## **Response to submissions – Minto Resource Recovery Facility (SSD 7462)**

This letter responds to the items raised in the *Bingo Resource Recovery Facility, 13 Pembury Road, Minto (SSD 7462) Request for Response to Submissions*, issued on 22 August 2017 and 14 February 2018.

A submission comprising a letter (dated 22 August 2017) was received from DPE. Several comments were provided and responded to in Table 1. Additional comments were provided via email on 14 February 2018. These additional comments have been incorporated and responded to within Table 1 below.

13 PEMBURY ROAD,
MINTO
LOT 1 DP 1013852

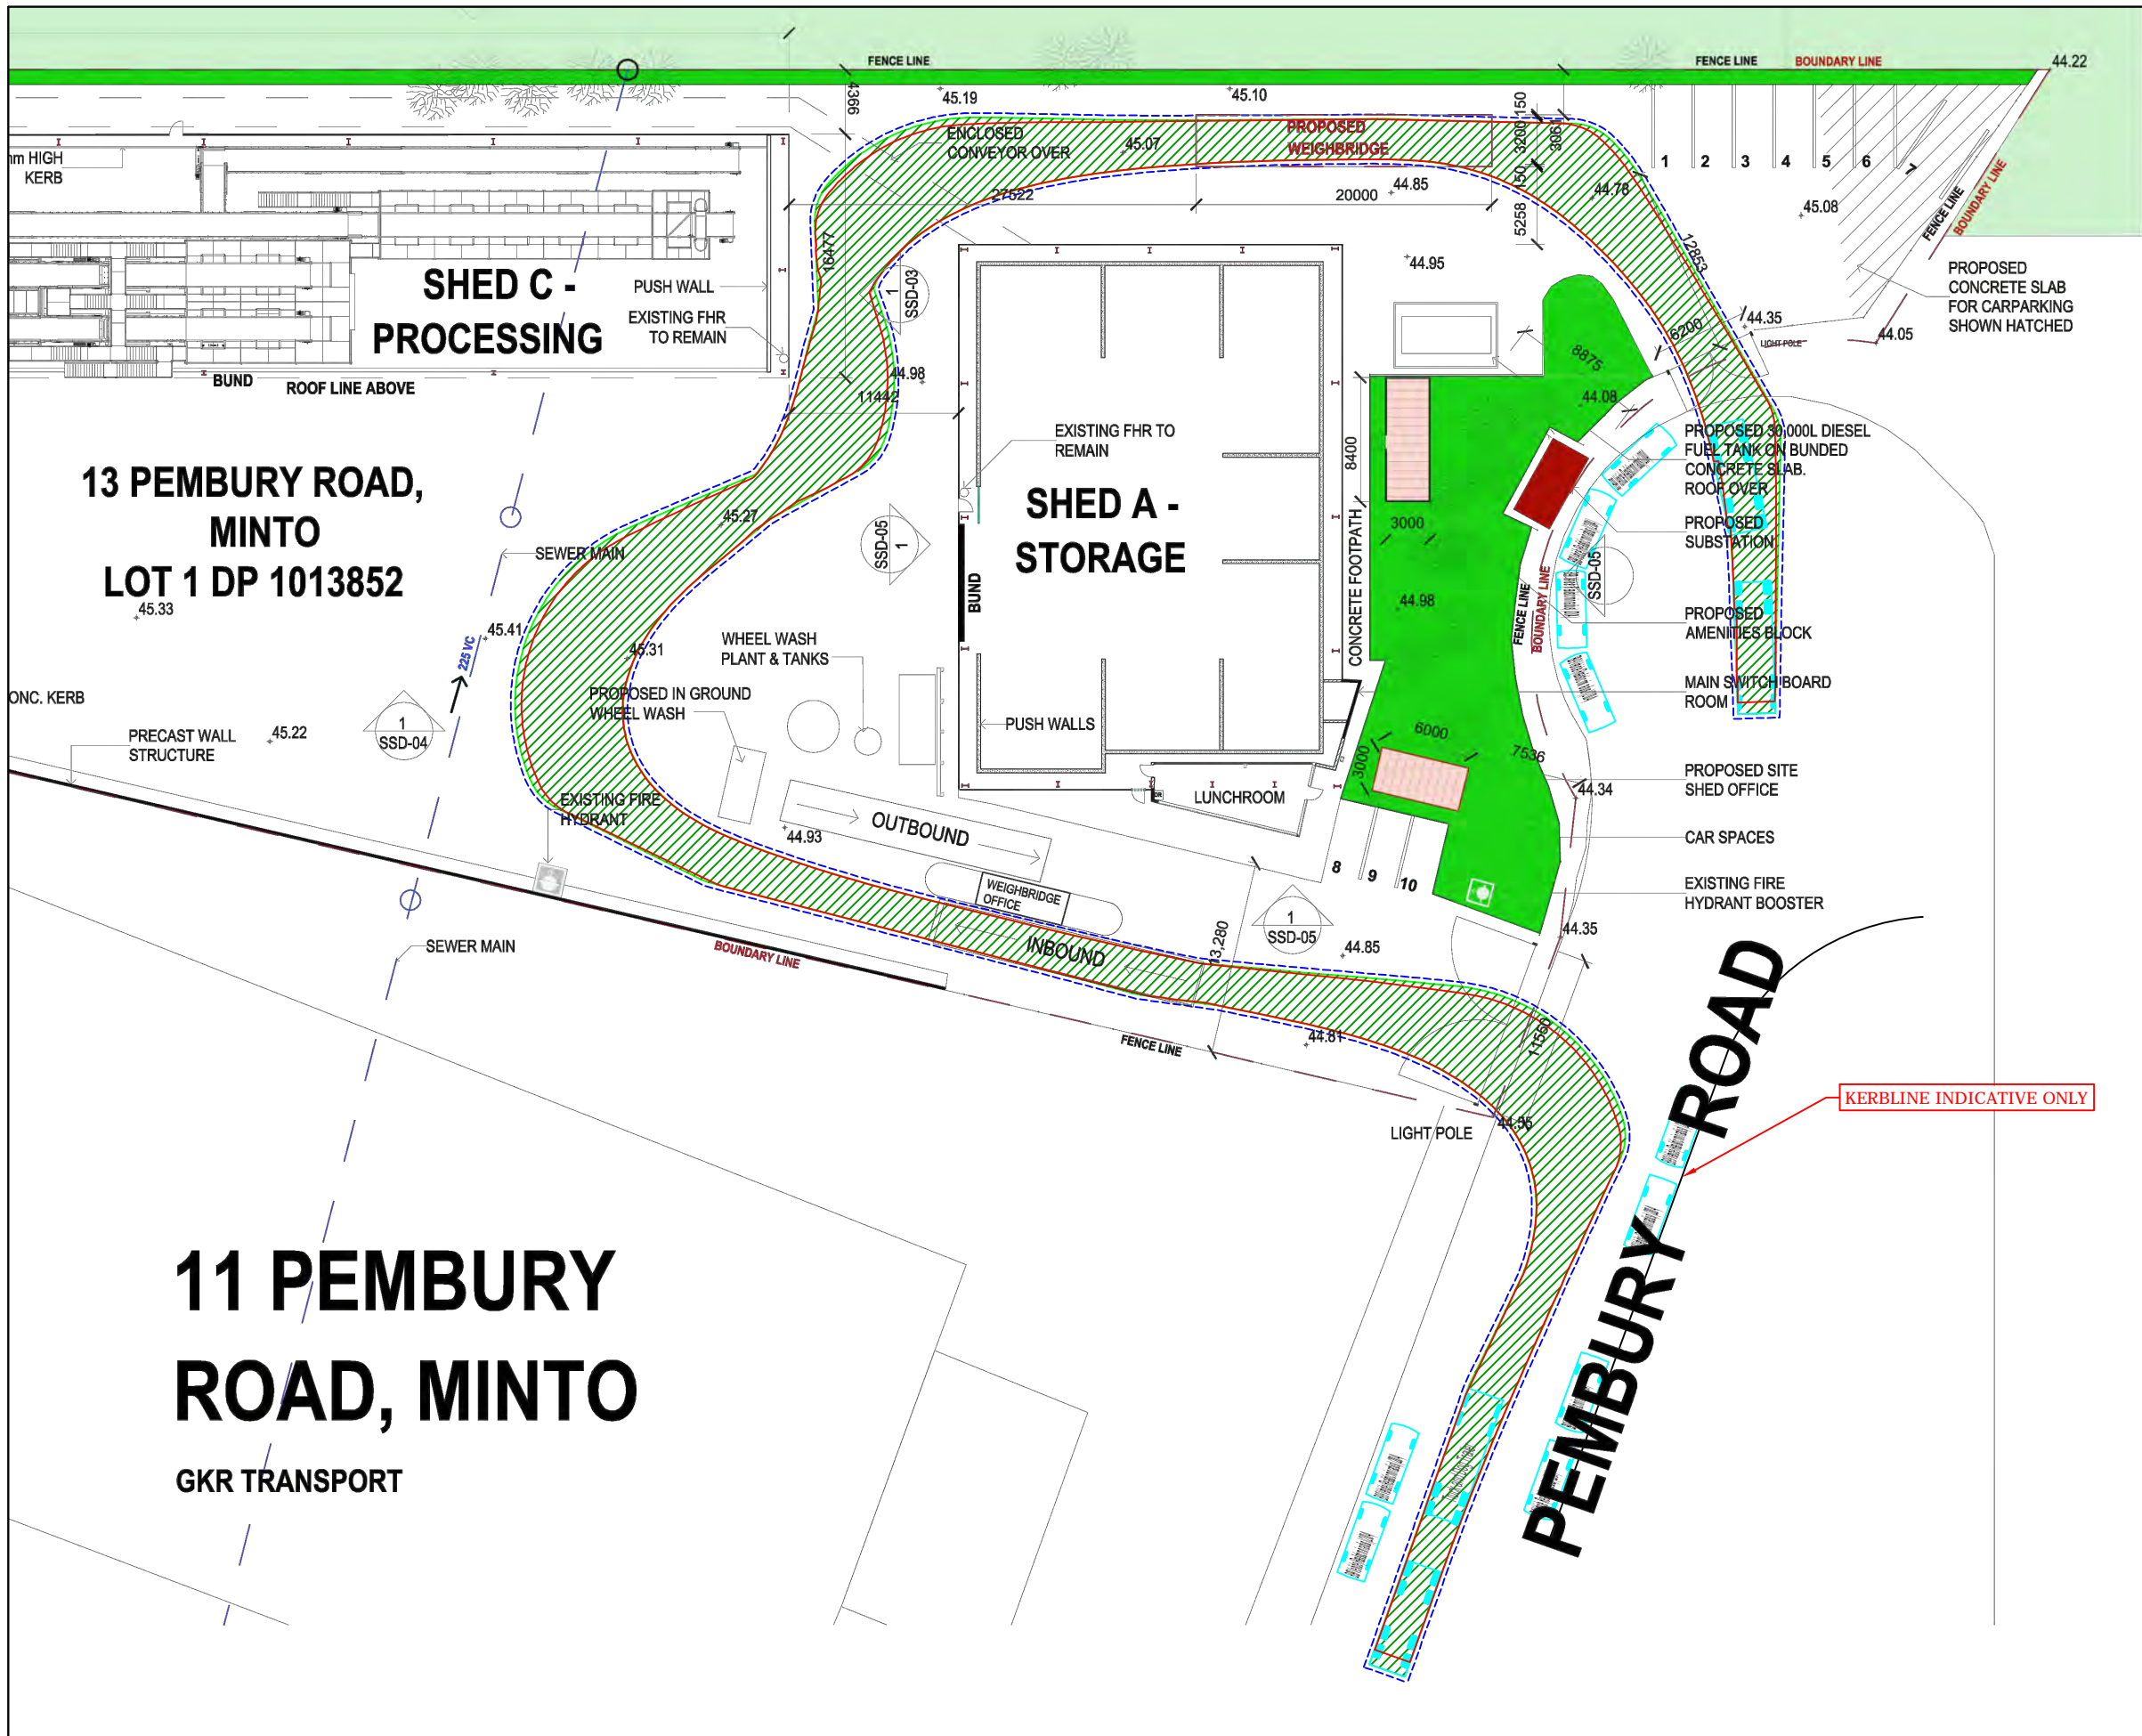
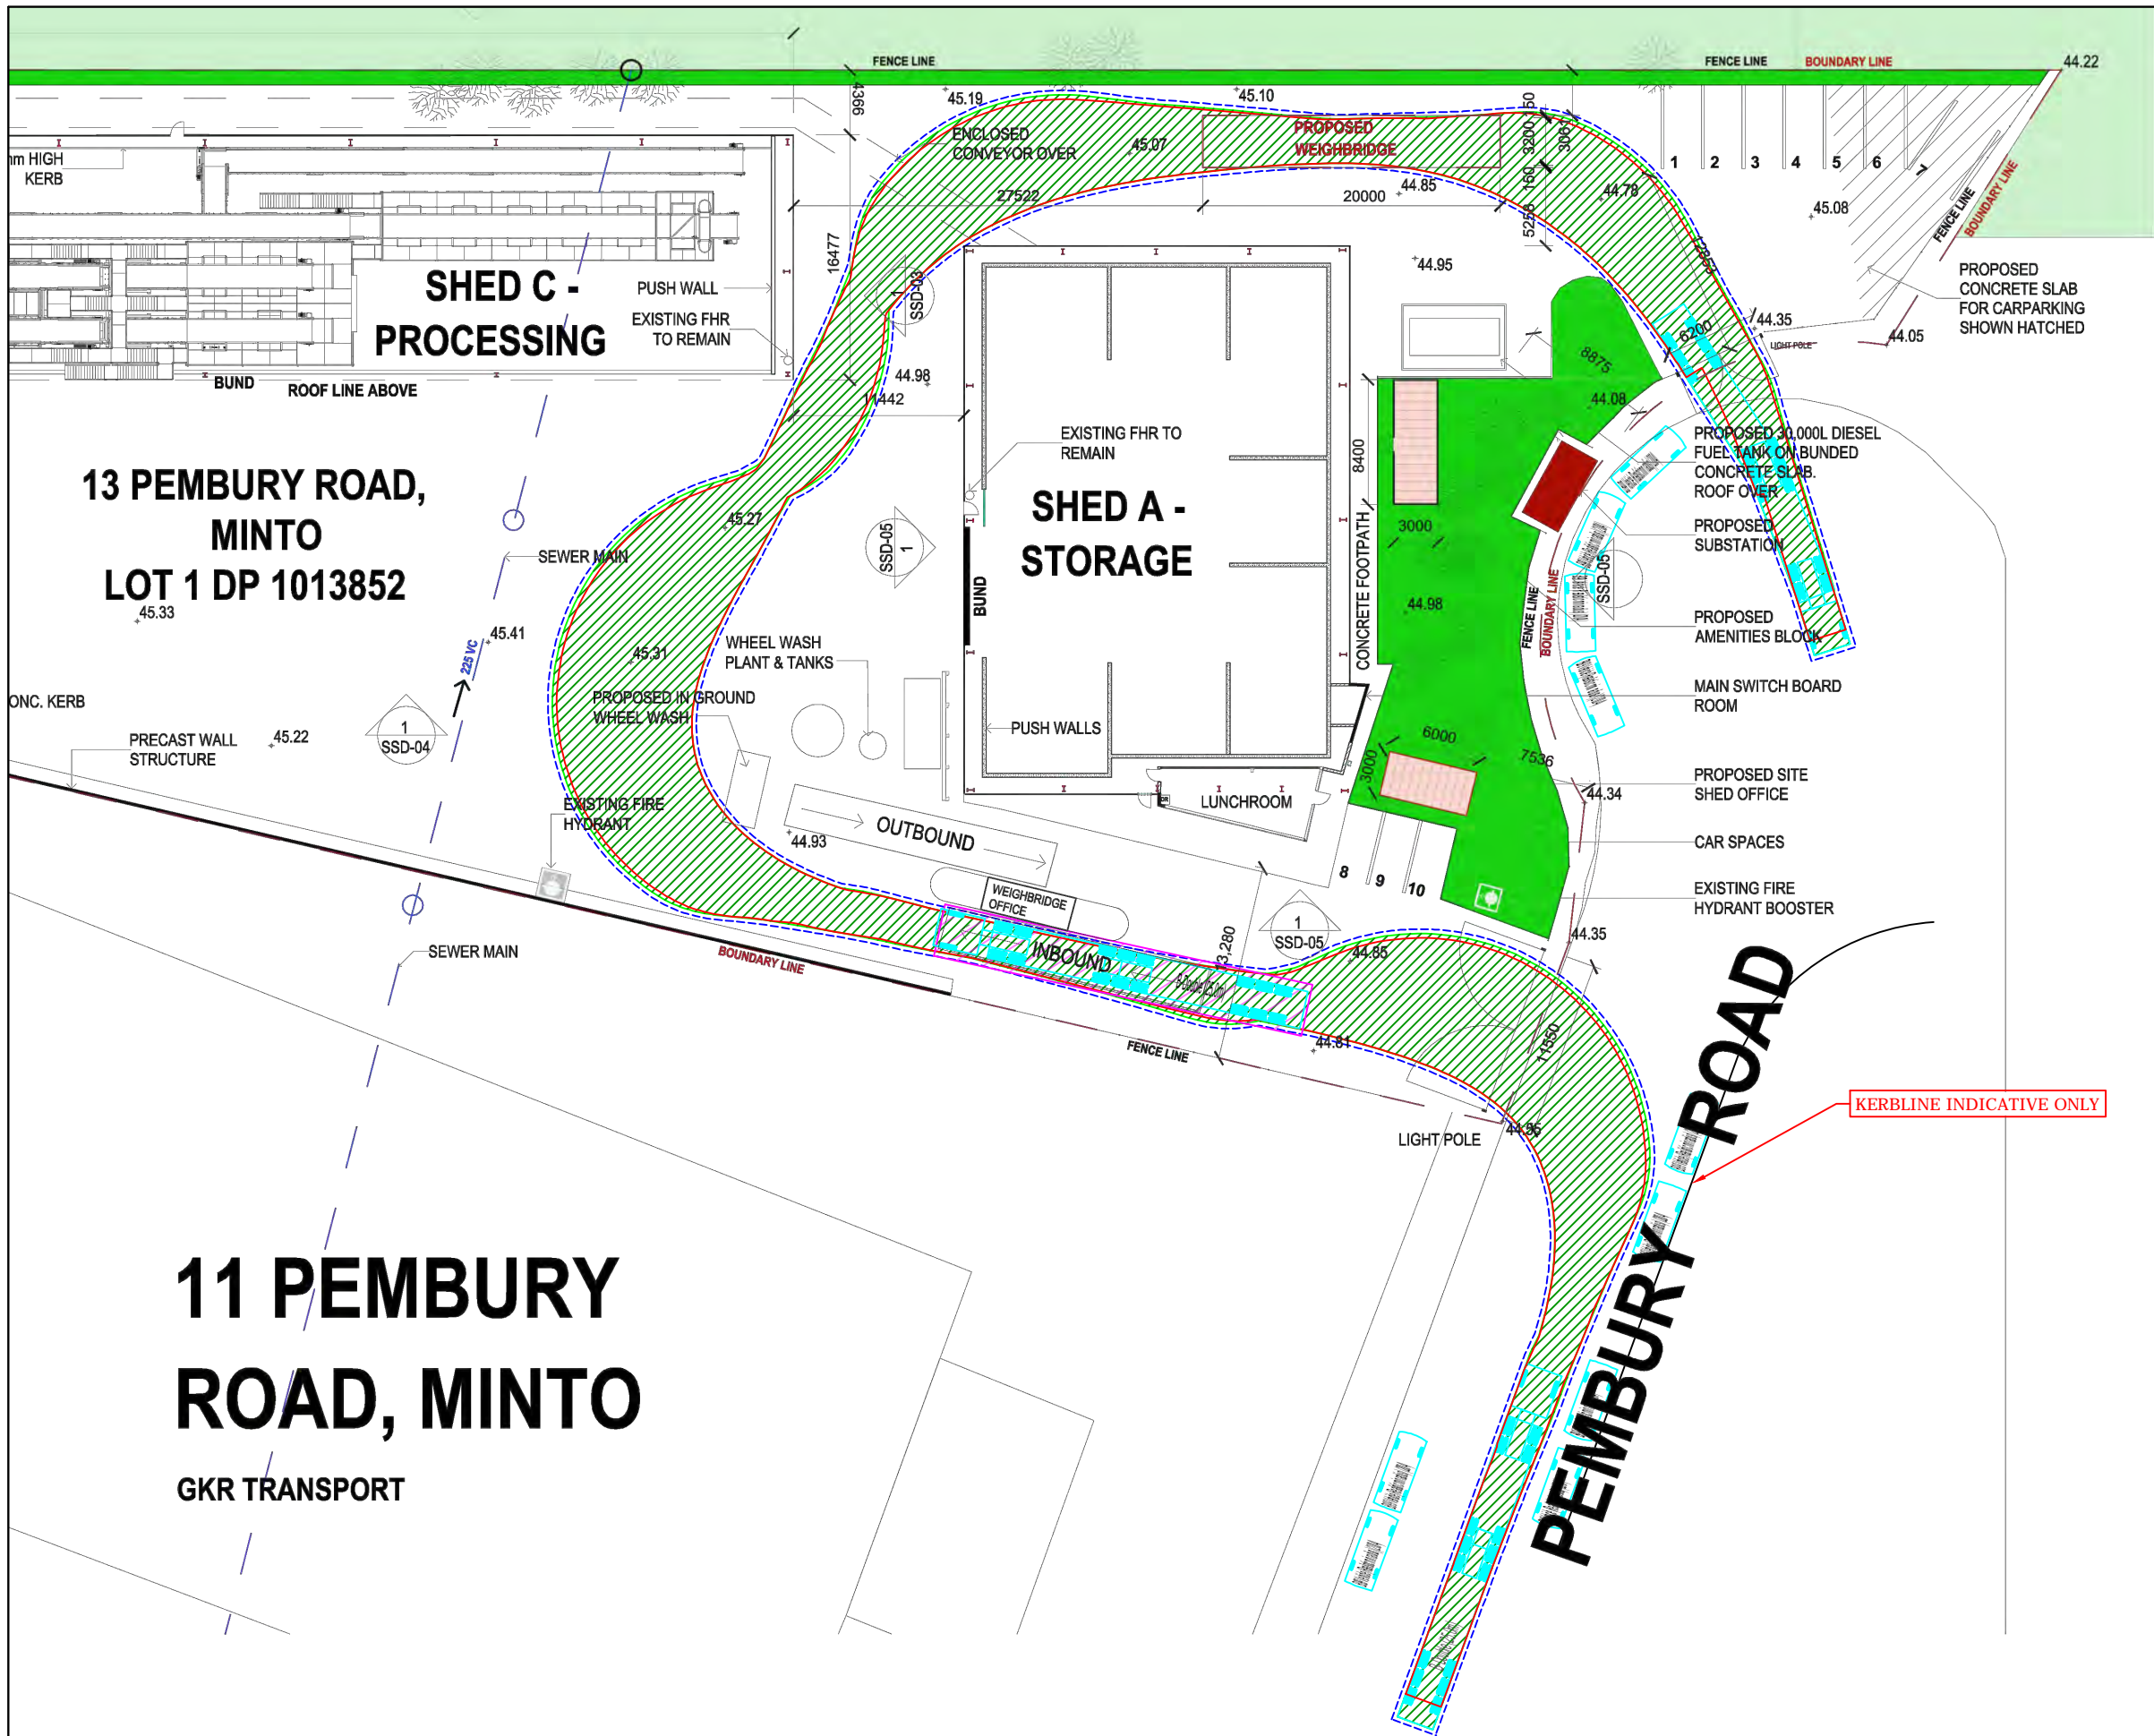
Provide plans showing the swept paths of the front-end loader proposed to be used to move waste on-site and vehicles used for waste collection. The plans should include the stacking of vehicles within the site to demonstrate there is sufficient space onsite at peak periods.	<p>As noted and described in Section 6 of this RtS a number of amendments have been made to the Proposal following the exhibition of the EIS in response to submissions received. These include amendments to further optimise the internal site layout and improve safety (demonstrated by amended swept path analysis) for vehicle movements within the Proposal site, including removal of minor internal walls and cladding. It is proposed to remove the northern wall of Shed C to ensure optimal swept paths can be achieved by heavy vehicles safely and efficiently.</p> <p>Movement of the excavator between Shed A and Shed C has been considered while assessing the site layout. The key movements for the excavator are as follows:</p> <ul style="list-style-type: none"> <li>When there would be a waste collection truck loading-up adjacent to Shed A, the excavator would complete short movements between the waste storage bays within Shed A and a truck parked alongside Shed A.</li> </ul>	Section 6 of the RtS Addendum TIA (Appendix I of this RtS)
